**SPORT
ENGLAND**

Application Number: 3/2011/0558

Site Address: Grindleton Recreation Ground, Sawley Road, Clitheroe BB7 4QS

Proposal: Resubmission for change to approved consent 3/2011/0001P of building new community hall with changing facilities, kitchen, storage etc. Demolition of existing changing facilities.

Site Layout

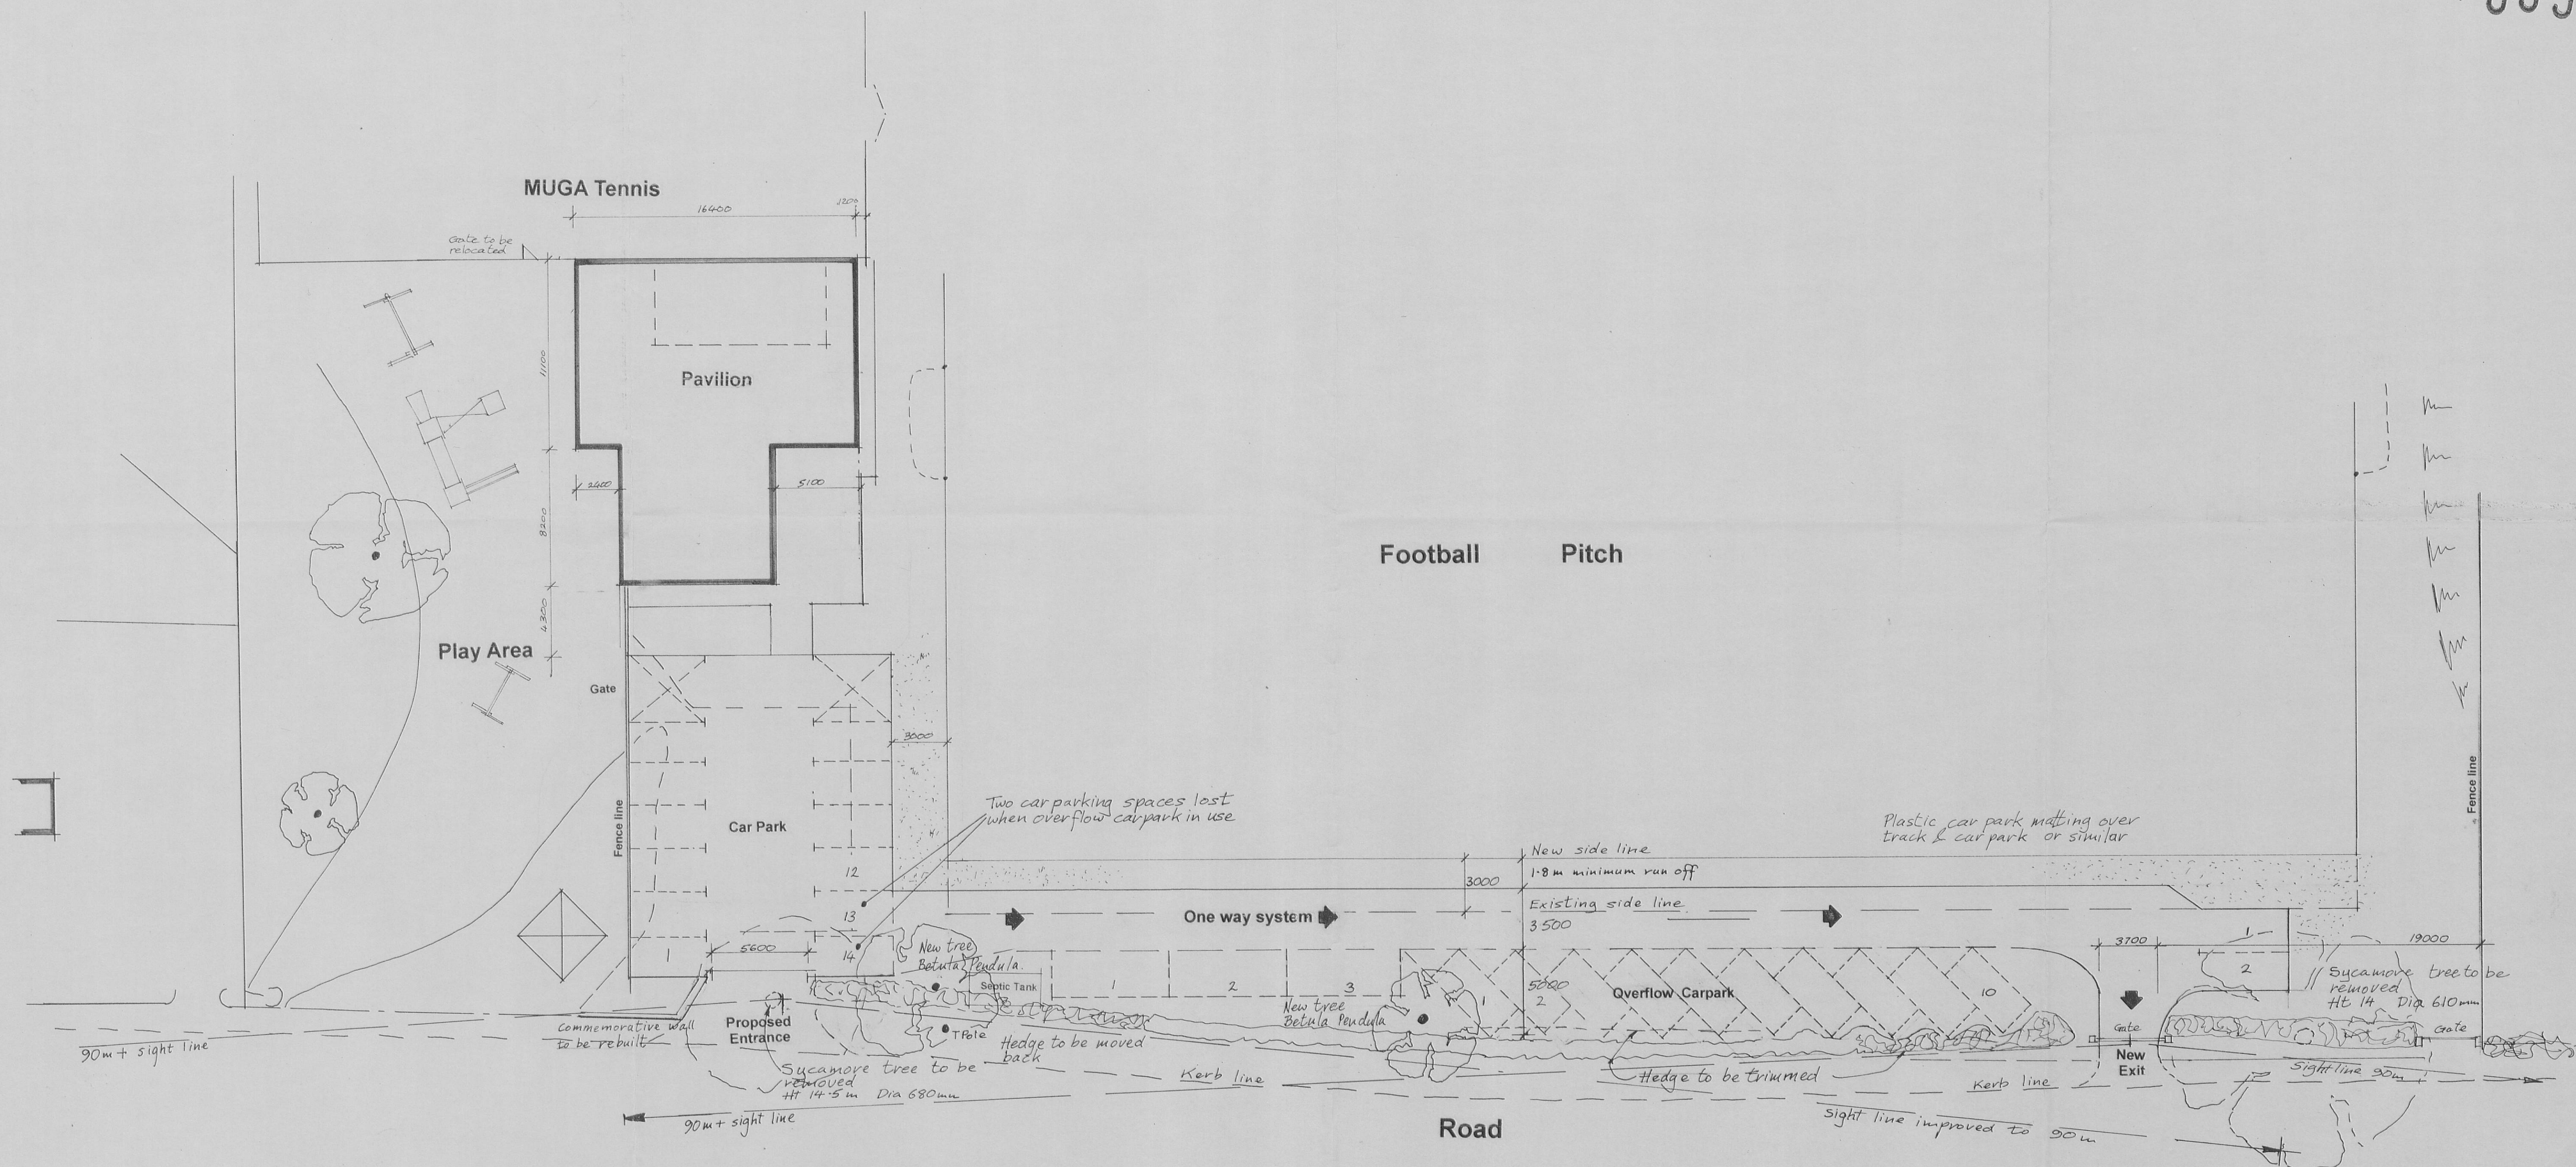
Due to the fact that the existing playing field does not have a full drainage system installed (only part of the field benefits from one) I am prepared to be flexible in allowing the pitch to be moved by 4m to accommodate the car park and new

clubhouse, as the benefit will outweigh the impact. If the pitch had a full drainage system, I would have wanted to see an independent report. This flexibility is conditional that the pitch size is not reduced and the run offs are a minimum of 1.86m. I note that on the drawings submitted one of the hedges is only 1.8m away from the touchline.

Title Scheme Plan

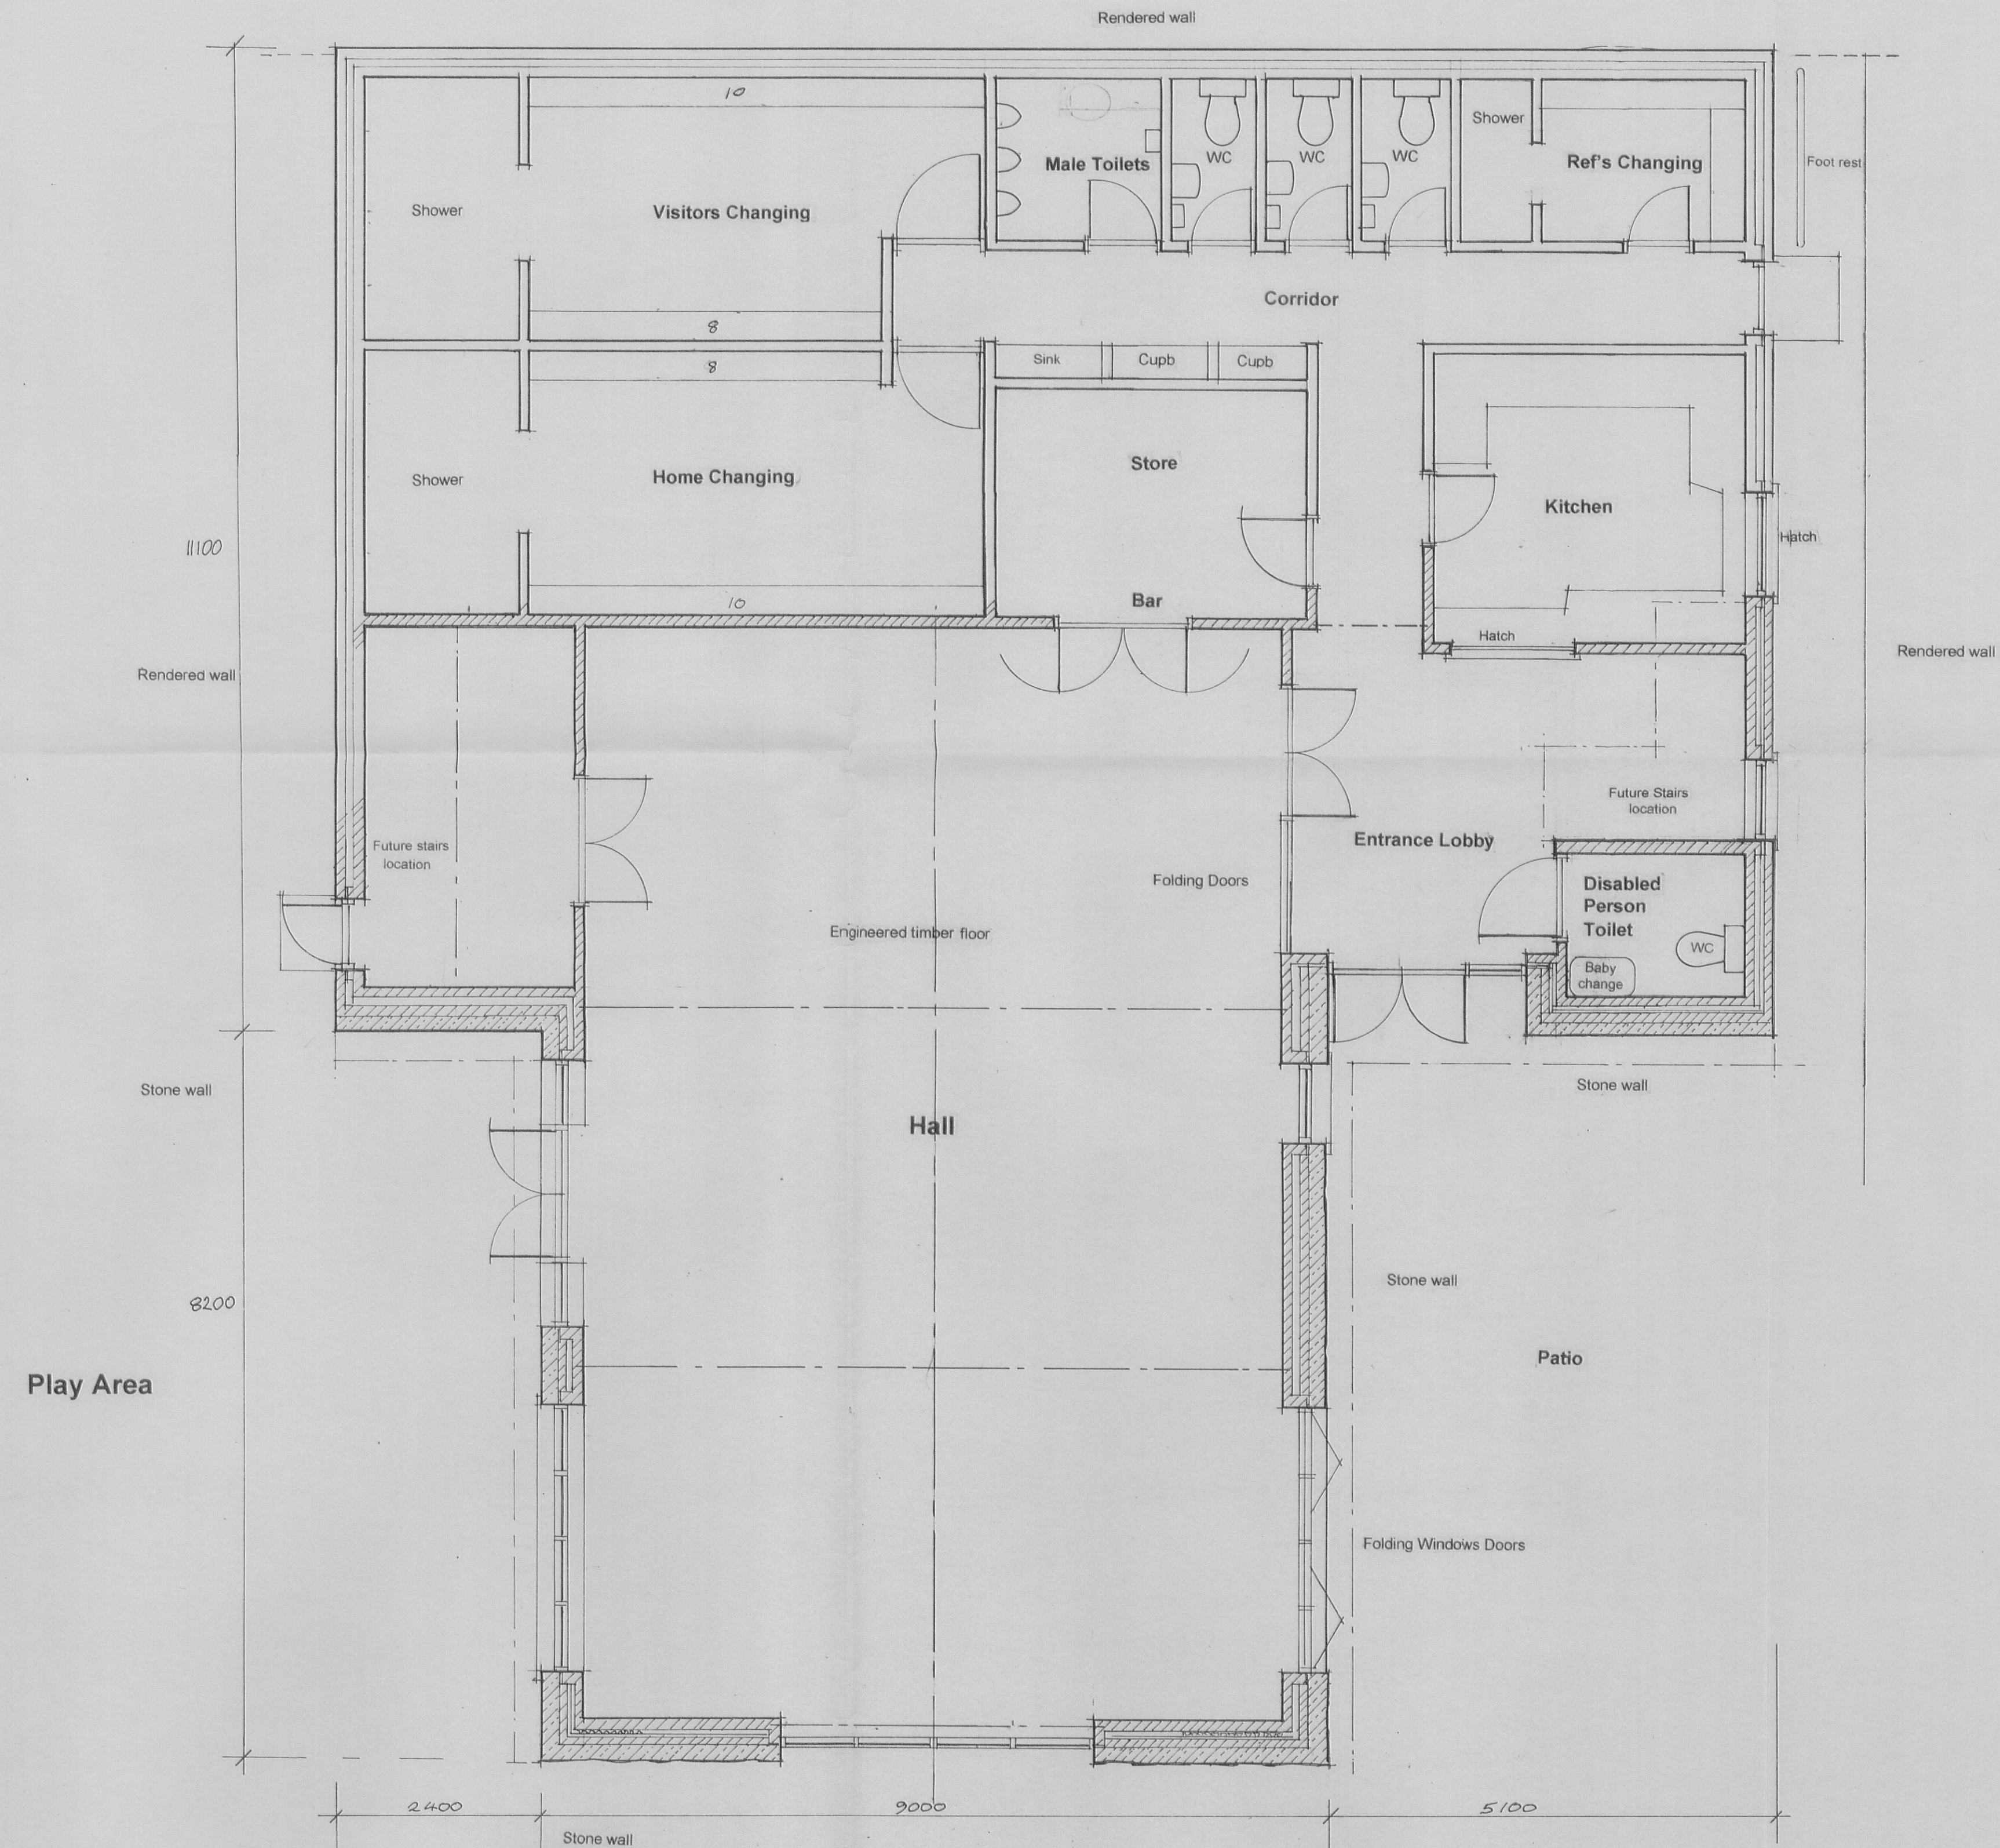
The proposed changing rooms do not comply to FA Standards for the following reasons:

- There is no modesty screening to any of the changing rooms or officials rooms.
- The changing rooms should be self contained and include 2 WC's and 2 wash hand basins in addition to the shower area (4 heads required).
- The usable changing space should be 16m². With the above additions the size of the changing rooms may need to increase.
- We recommend that the spectator toilets are moved away from the "dirty" area used by the players to avoid easy access to players and officials.
- We recommend that two officials rooms are build to accommodate male and female officials.
- Examples of the above points and further guidance can be found under item 3 on the following link

*Prior to commencement of the development **details of the design and layout** of changing rooms, which shall comply with NGB Technical Design Guidance Notes to include 'Changing Accommodation', shall be submitted to and approved in writing by the Local Planning Authority in consultation with Sport England. The changing rooms shall be constructed in accordance with the approved design and layout details.*
